Narromine Shire Council

Response to Submission of Environmental Impact Statement
State Significant Infrastructure
Inland Rail- Narromine to Narrabri SSI-9487

Figure B3.3 **Predicted flooding extents**
- operation (one per cent AEP event) (map 4)

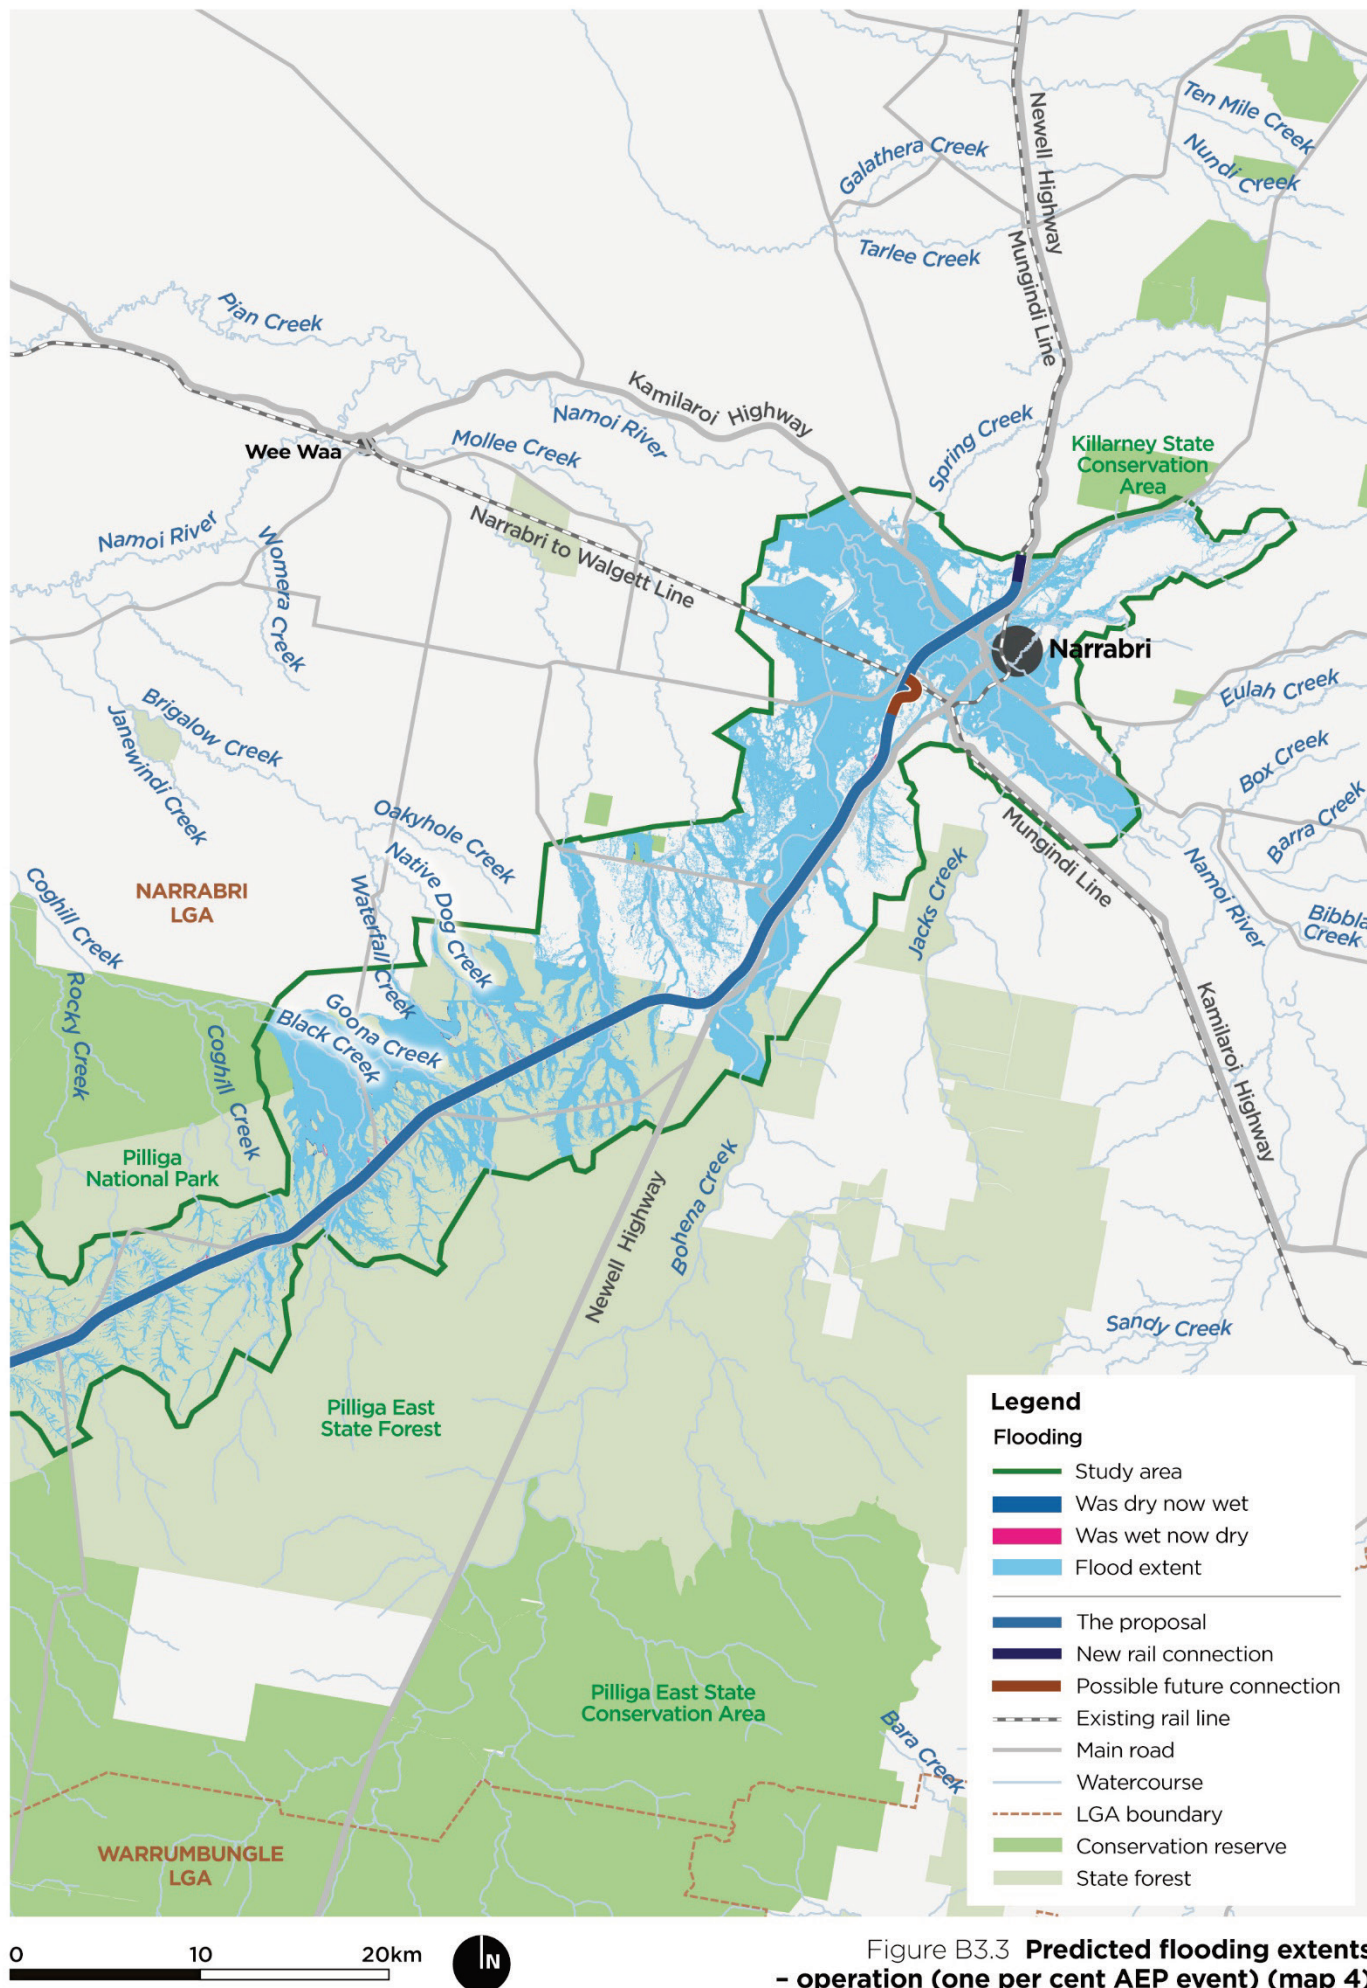
- Council expects more detailed flood assessment to be undertaken during detailed design to ensure flooding where the new rail line joins the old Narromine-Parkes rail line, including the area near Narwonah Siding, is well understood and managed accordingly.
- Council expects further detailed discussion and consideration of the future development of a town levee bank at Narromine aimed at protecting the township from flooding. Flood modelling at the detailed design stage must be undertaken in consideration of advice from Department of Planning, Industry and Environment.

Figure B11.1 Road network (map 1)

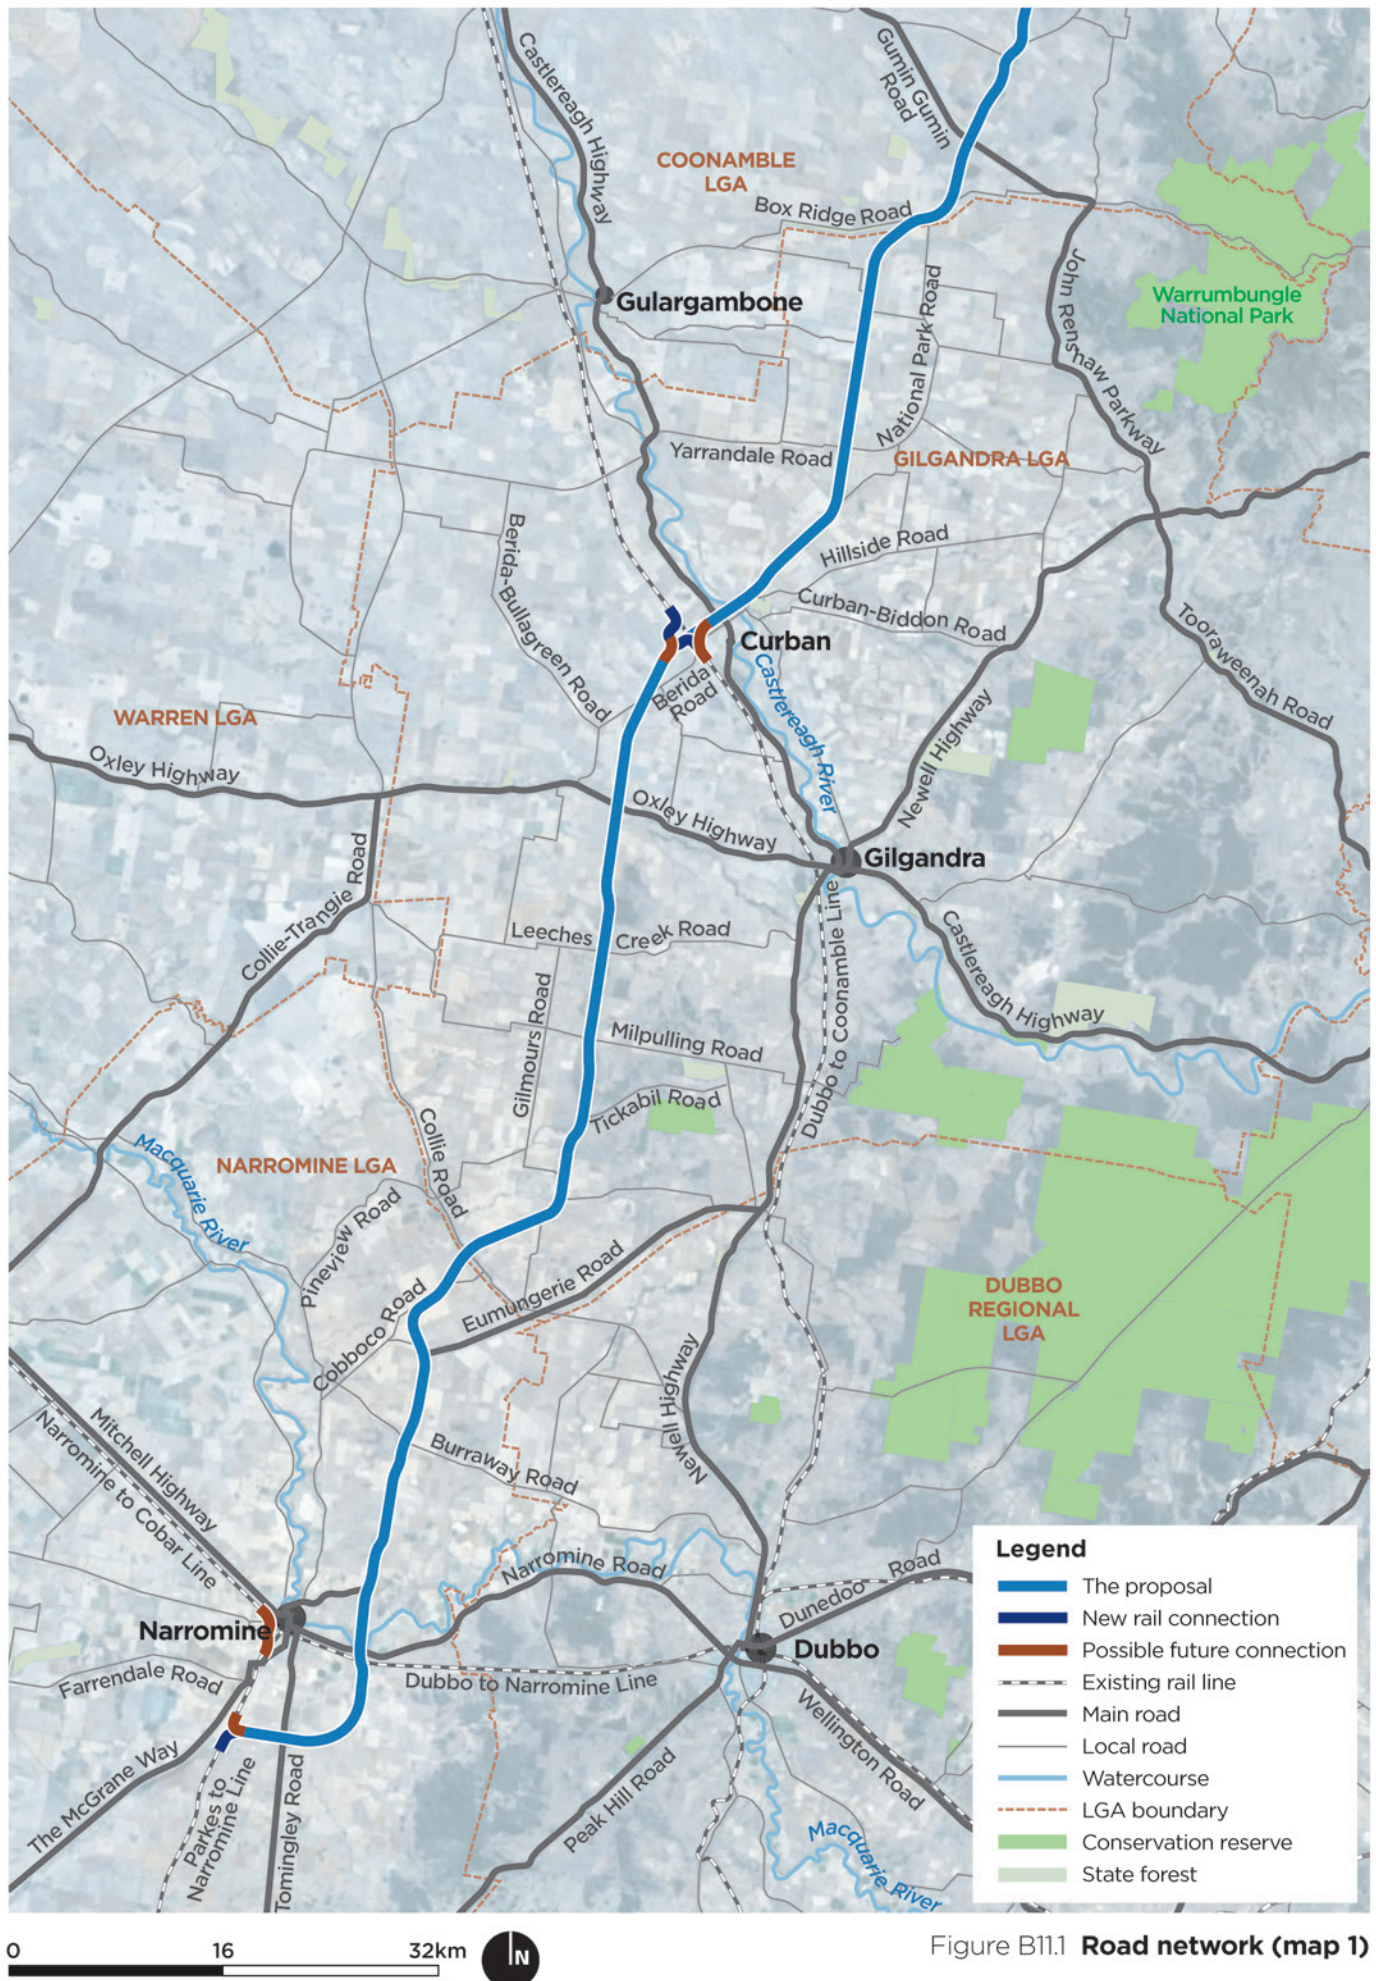
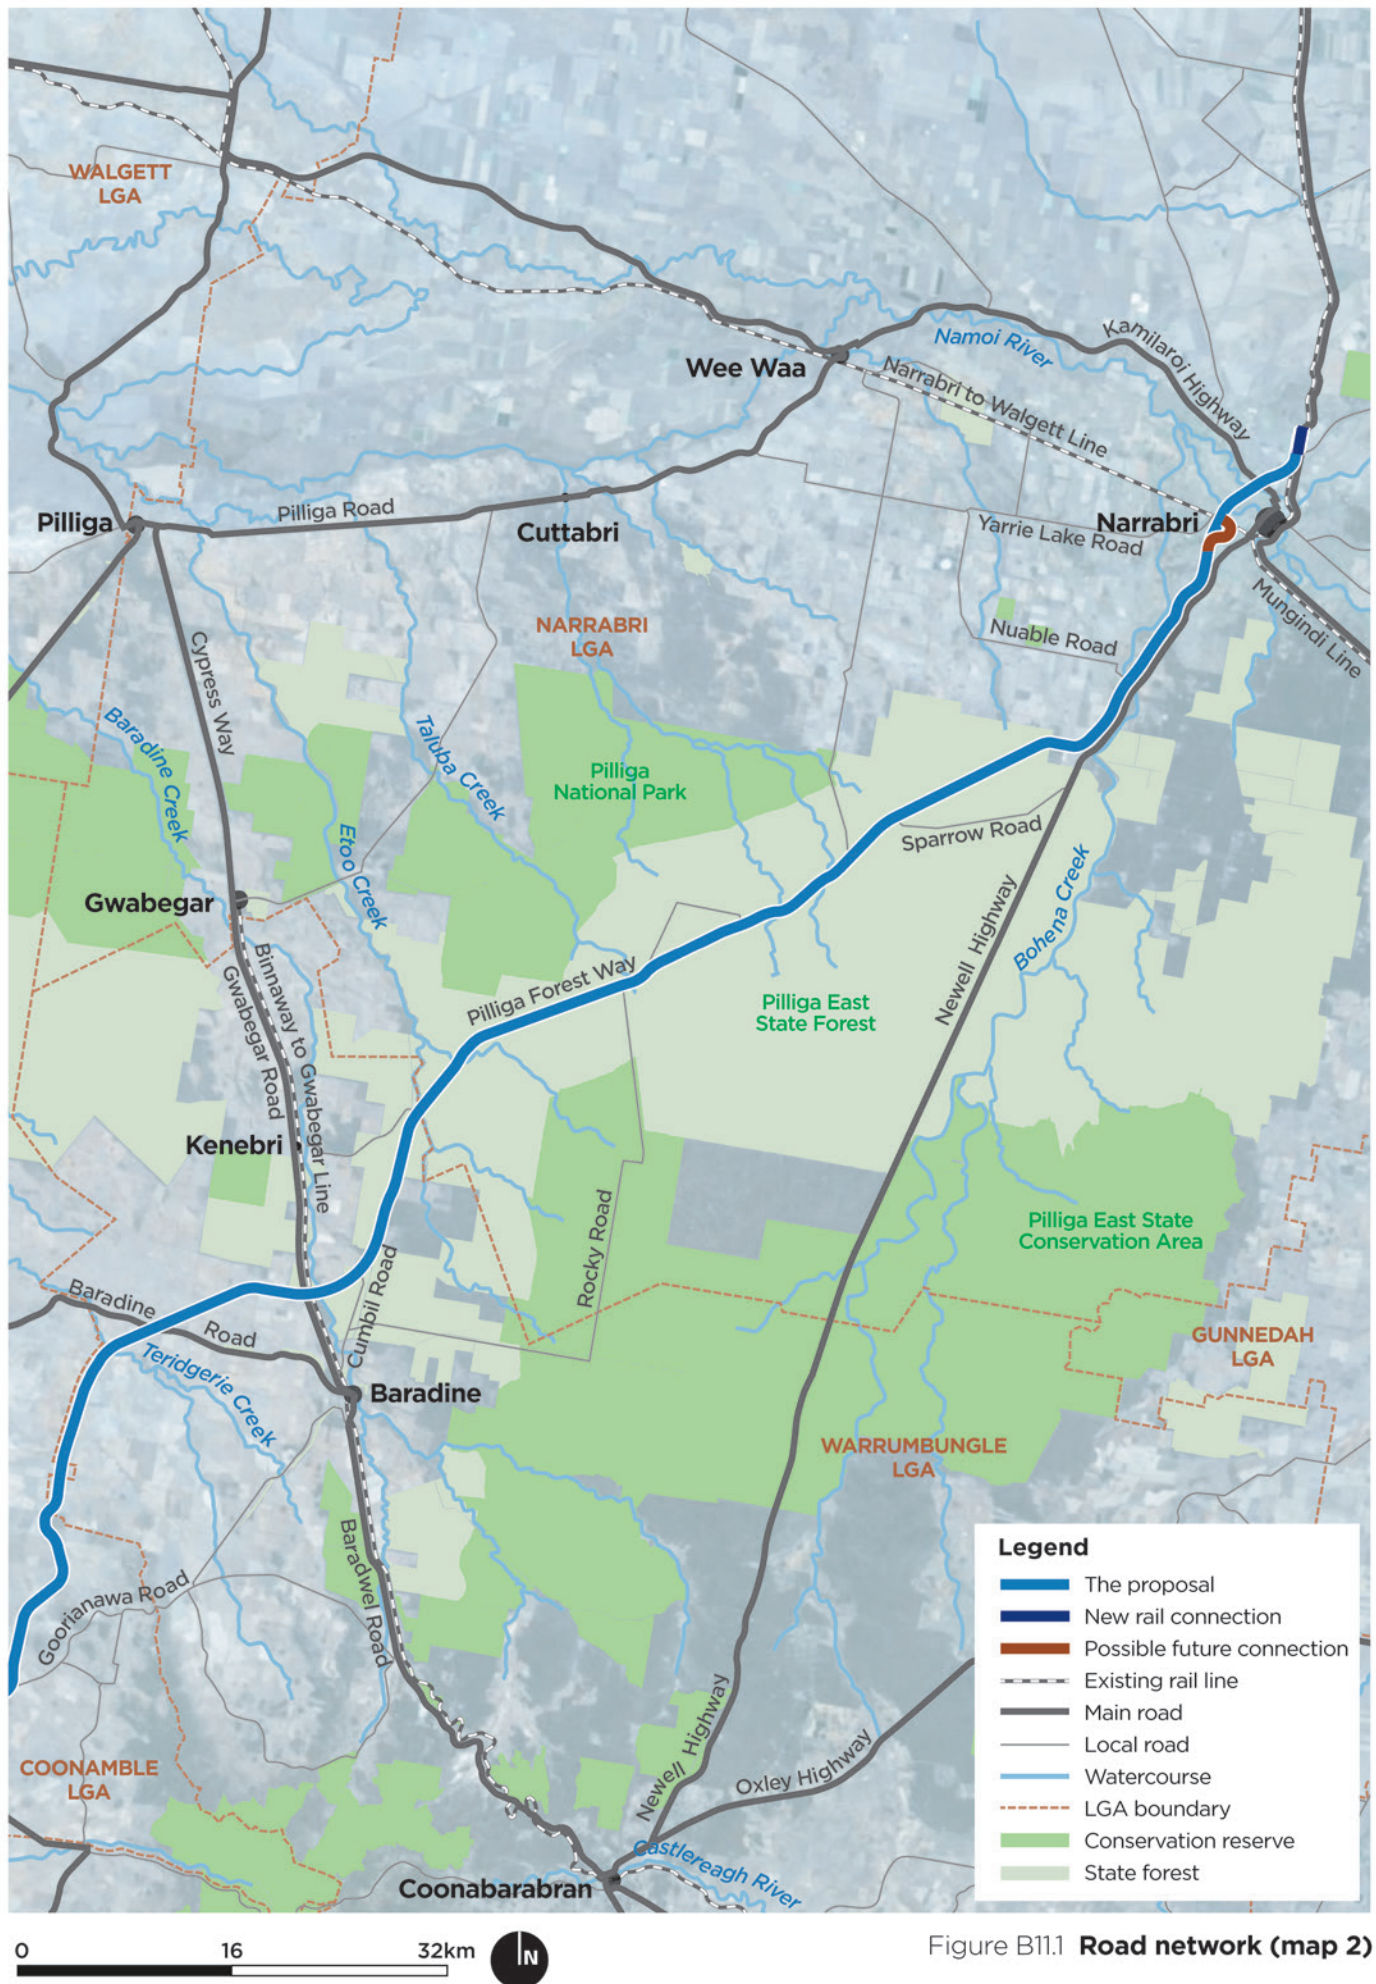
- Council requests to have the proposed active level crossings at Narromine-Eumungerie Rail Road and Tomingley-Narromine Road upgraded to include grade separation. This is an issue of high importance as this route attracts a large external traffic volume to Council roads and is imposing a maintenance cost issue on Council.

- Council requests the EIS disclose the extent of community consultation undertaken regarding the proposed closure of the eastern end of Dappo Road and provide reasoning for not making provision for a rail crossing at this location.
